MEMORANDUM

SUBJECT: SF-19-004 – Homestead Filing No. 2 Sterling Ranch
Third Submittal
LSC Response Below (3-3-2020)

Engineering Division

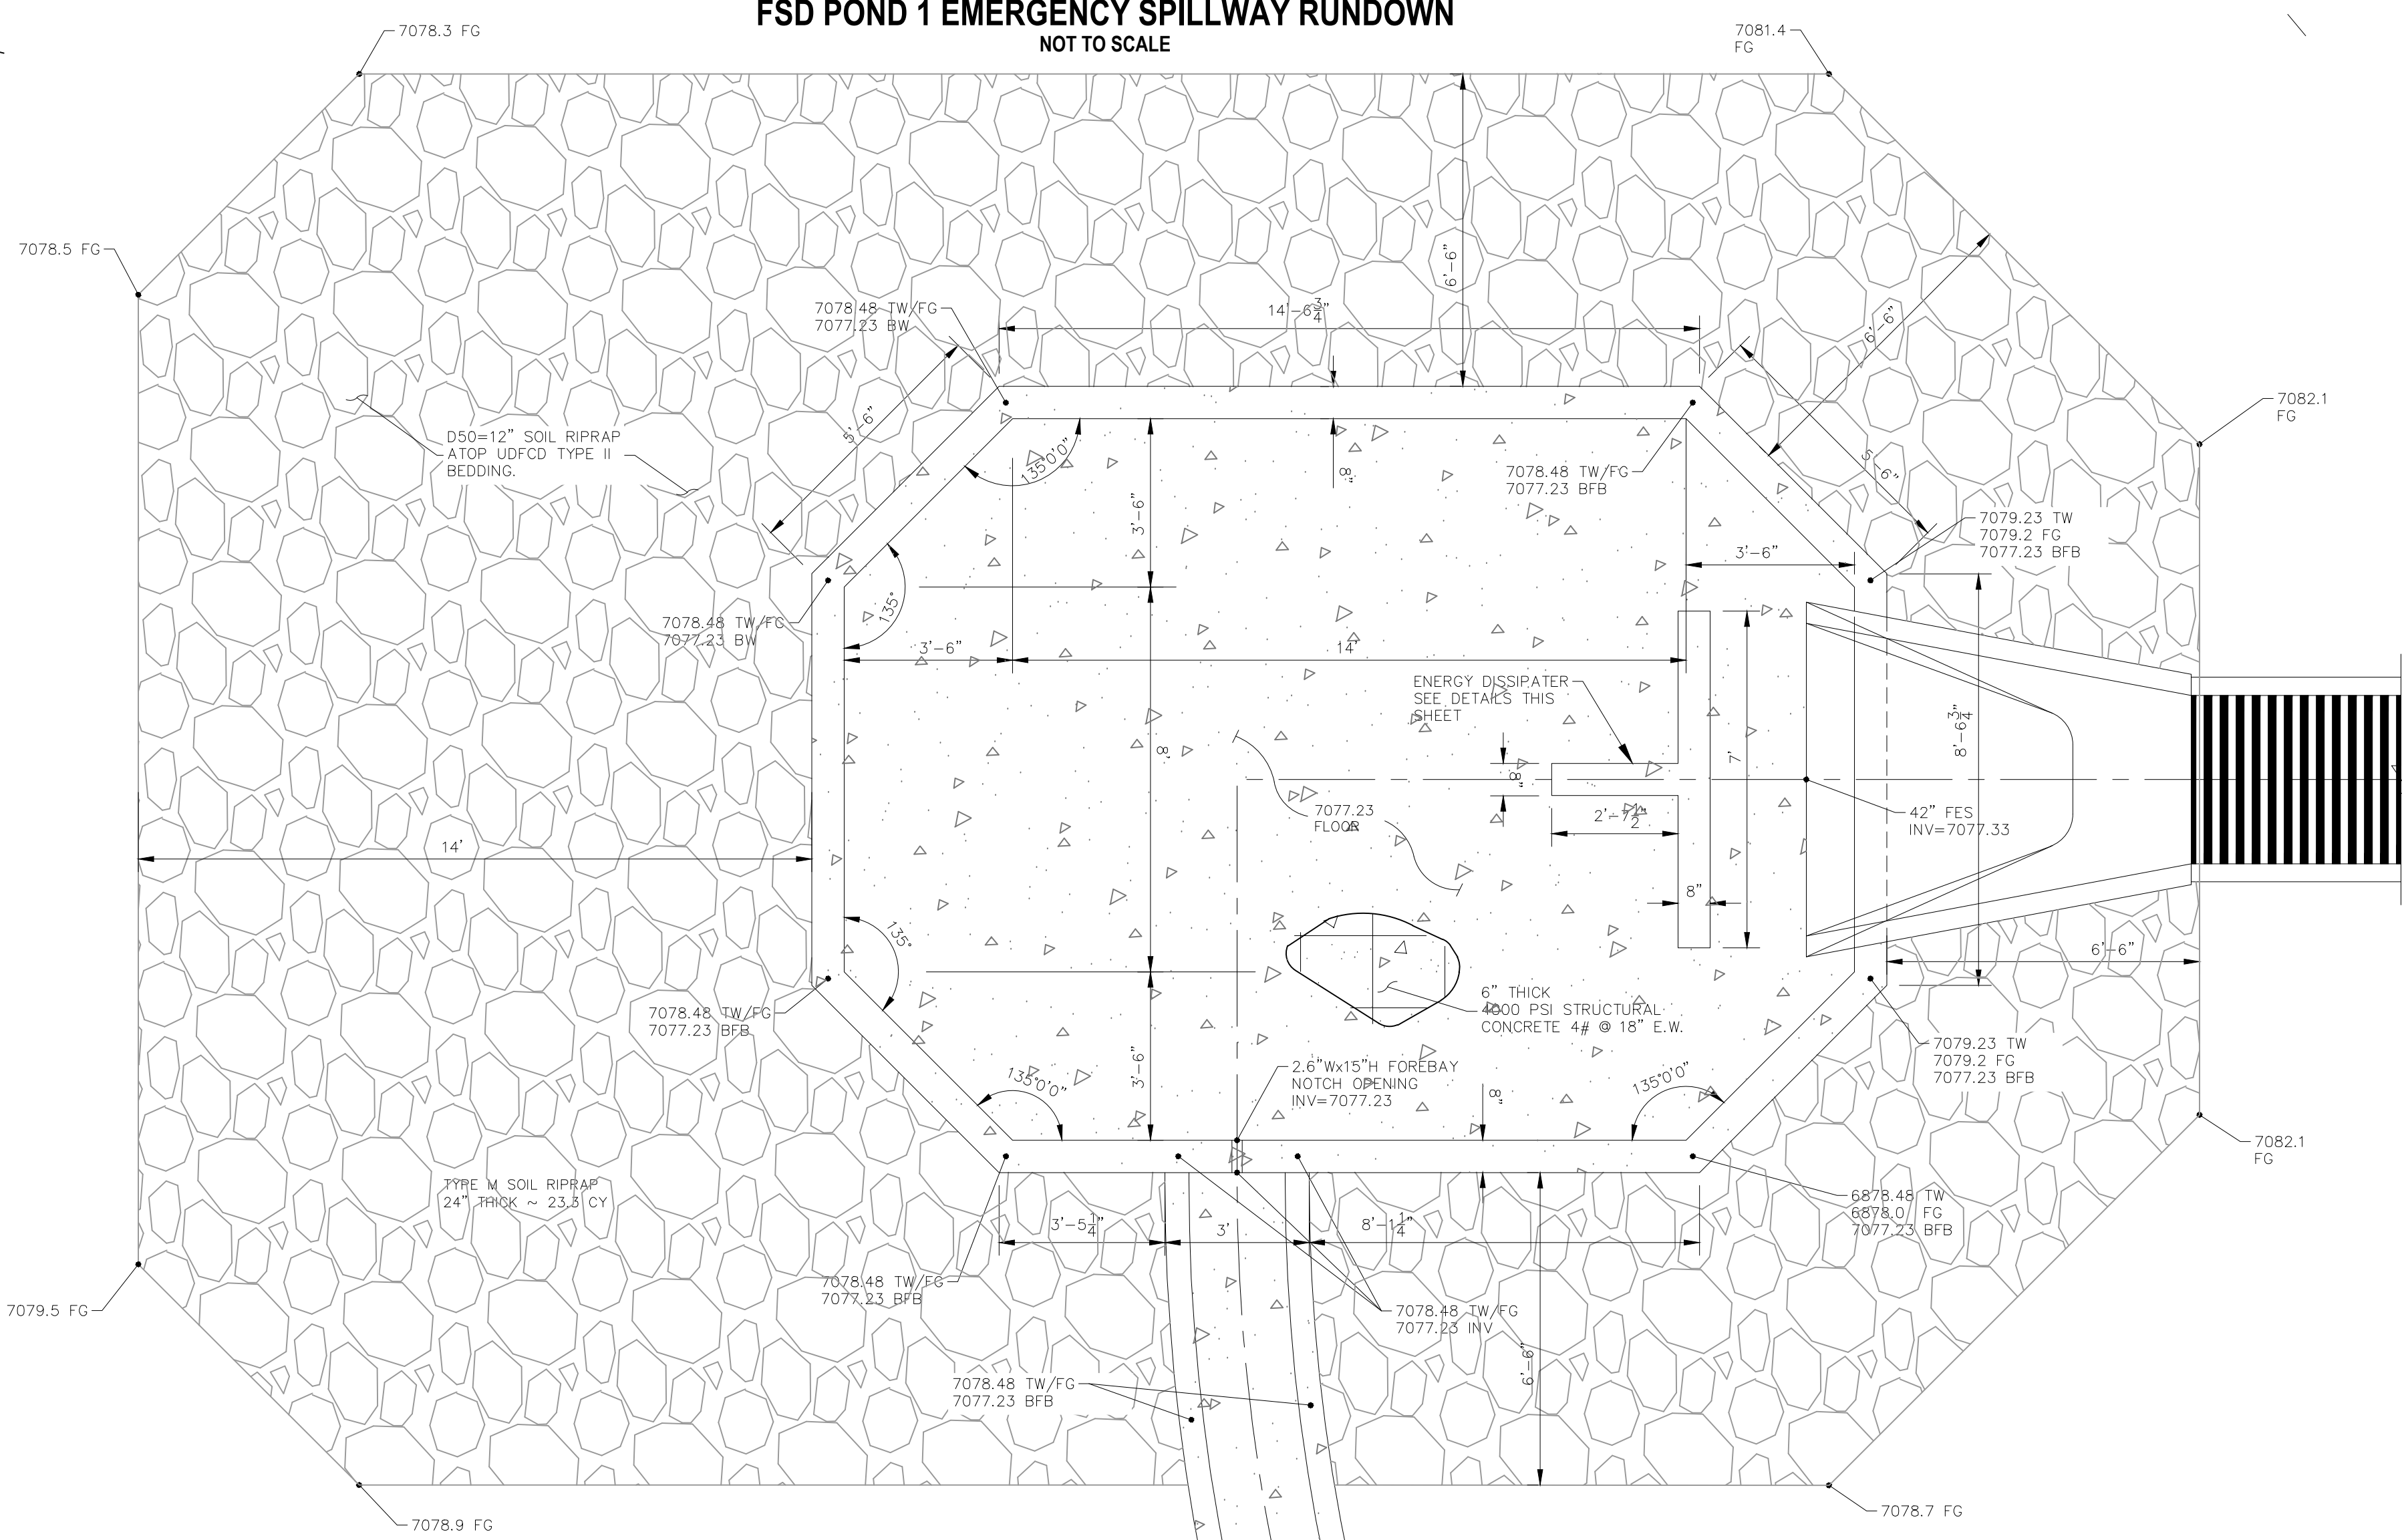
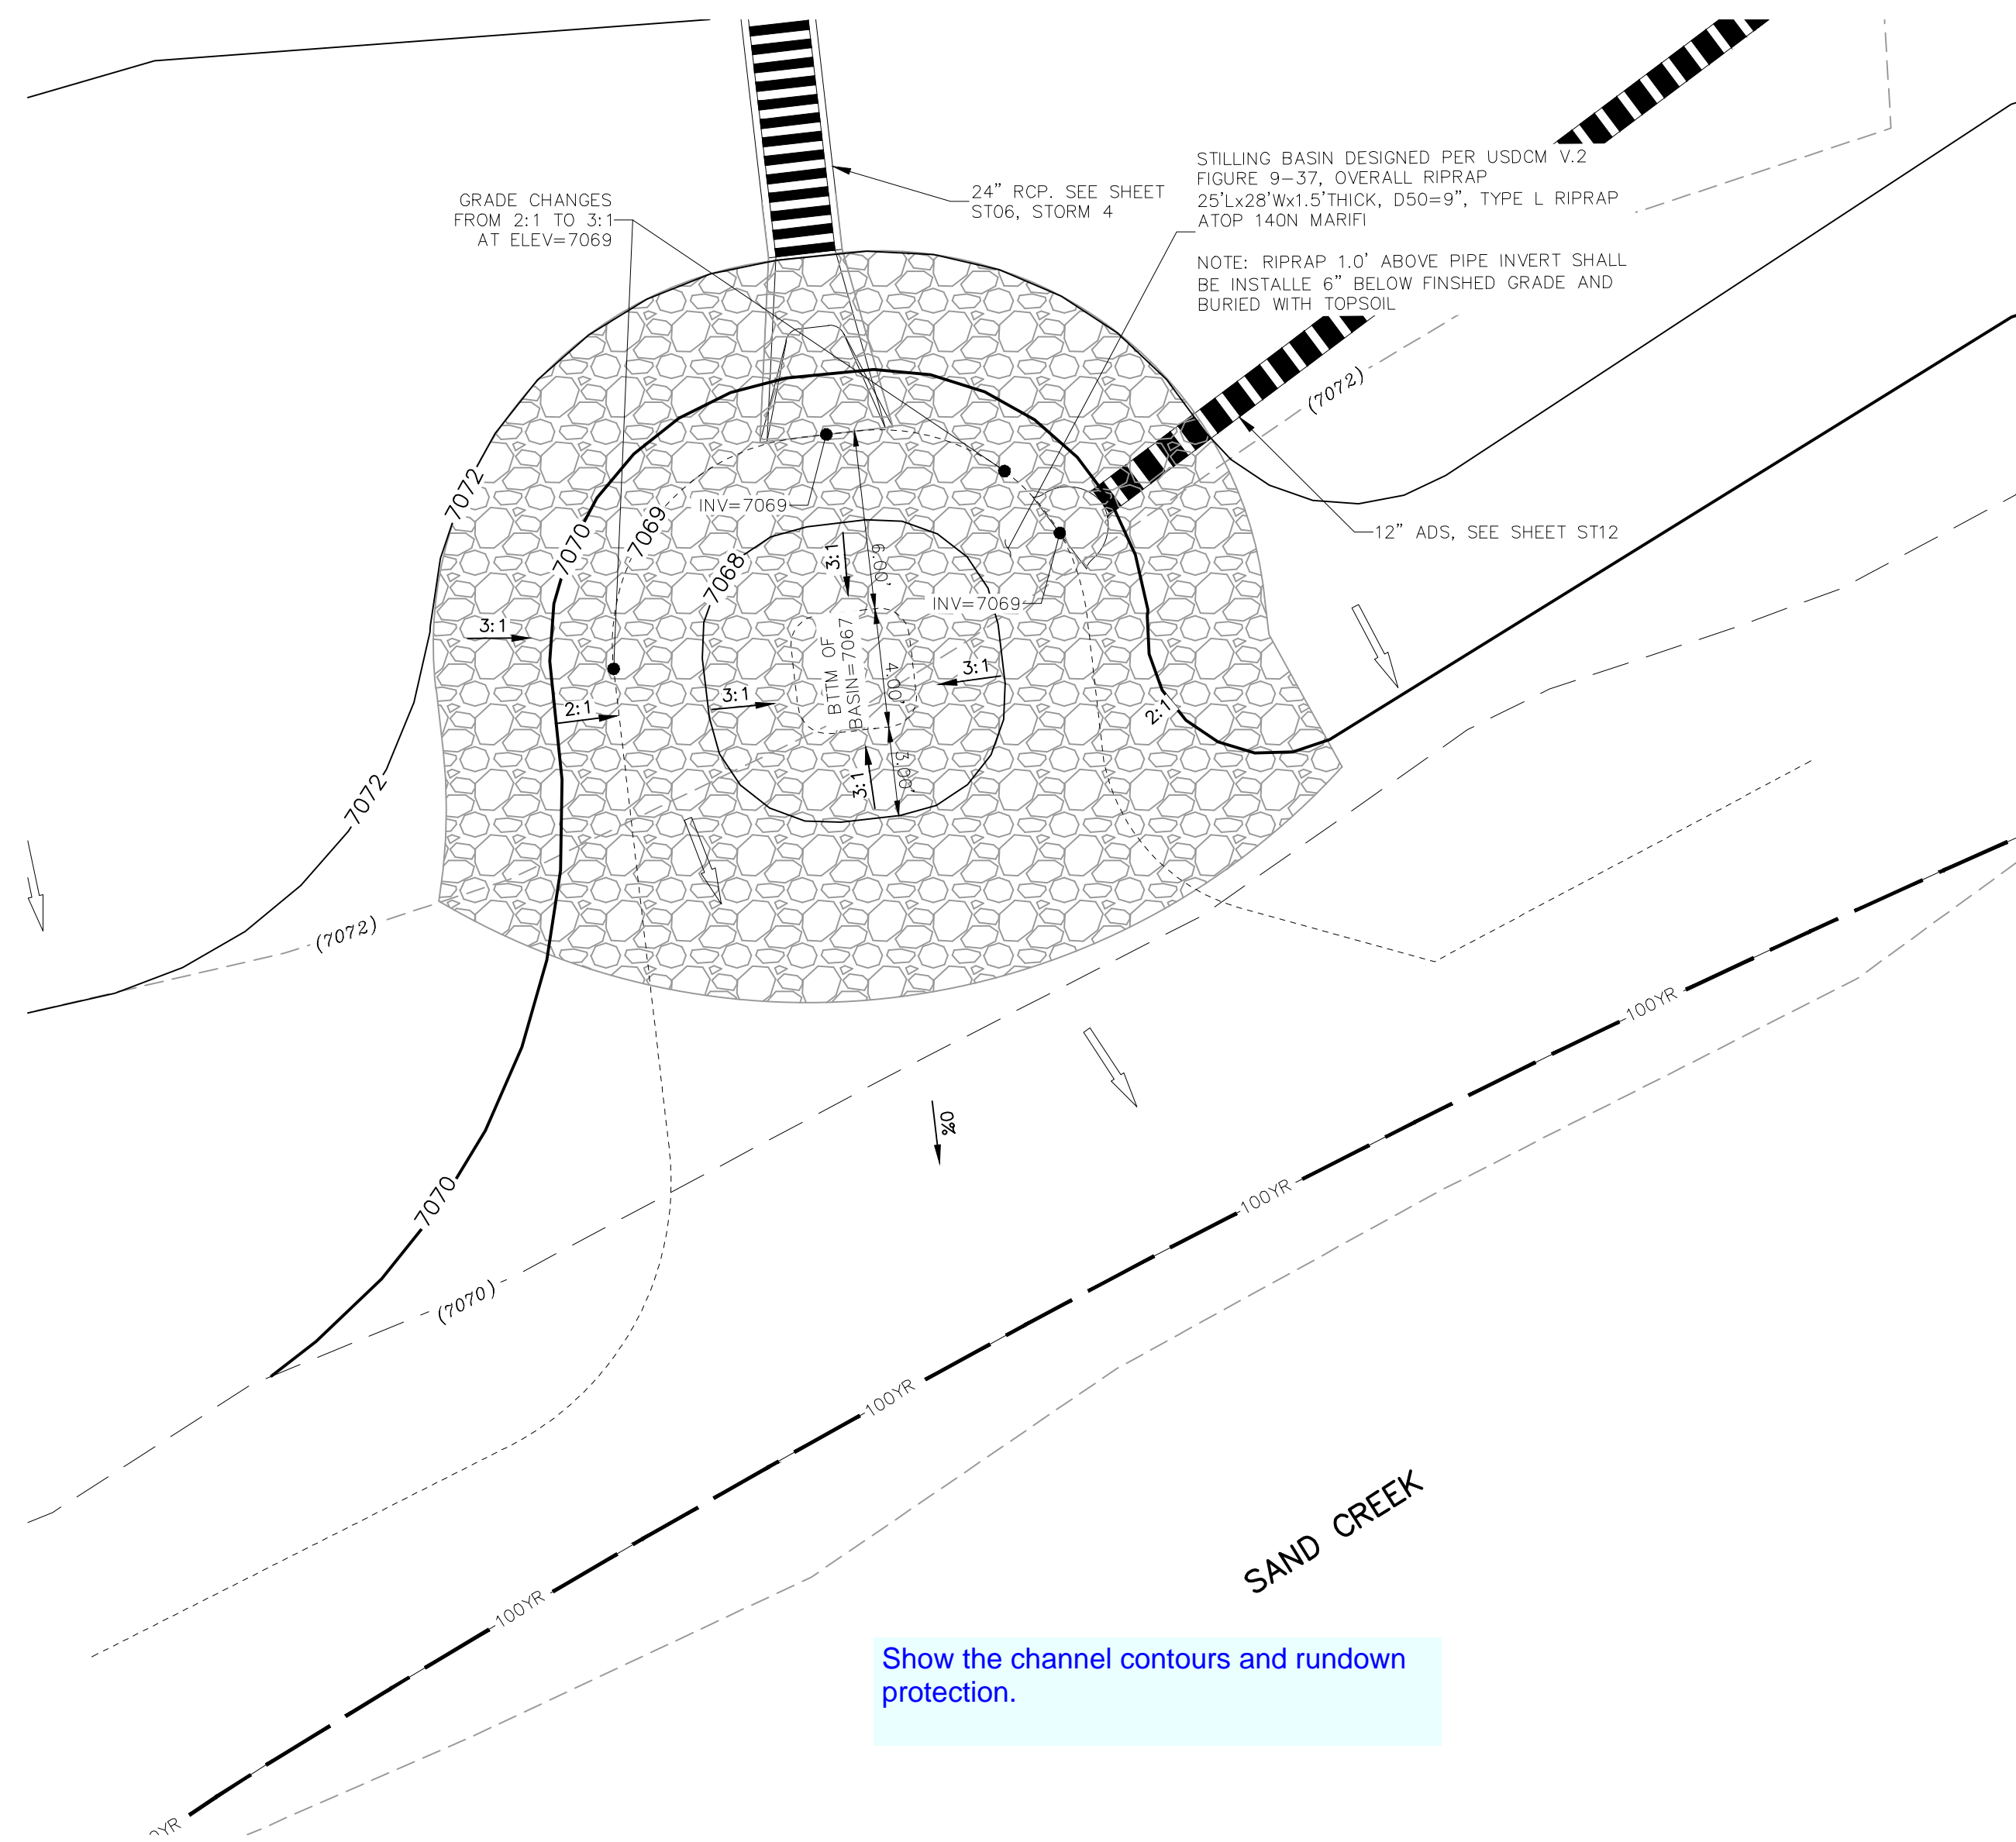
1. Revise to include adjacent Sand Creek Channel Improvements. (see Drainage report comments). (See Branding Iron Filing No. 2 CD comment #1.) **Provide the overall channel improvements plans when available.**
2. See storm sewer plans redlines.
 - a. See updated redlines. See also deviation request redlines regarding flow velocities at the Sand Creek outfall. **Comment resolved; however, an updated channel data sheet as noted in the response letter was not found.**
 - b. **Resolved.**
3. **The bank stabilization plans provided contain apparent inconsistencies regarding the types of bank stabilization proposed. See redlines.**
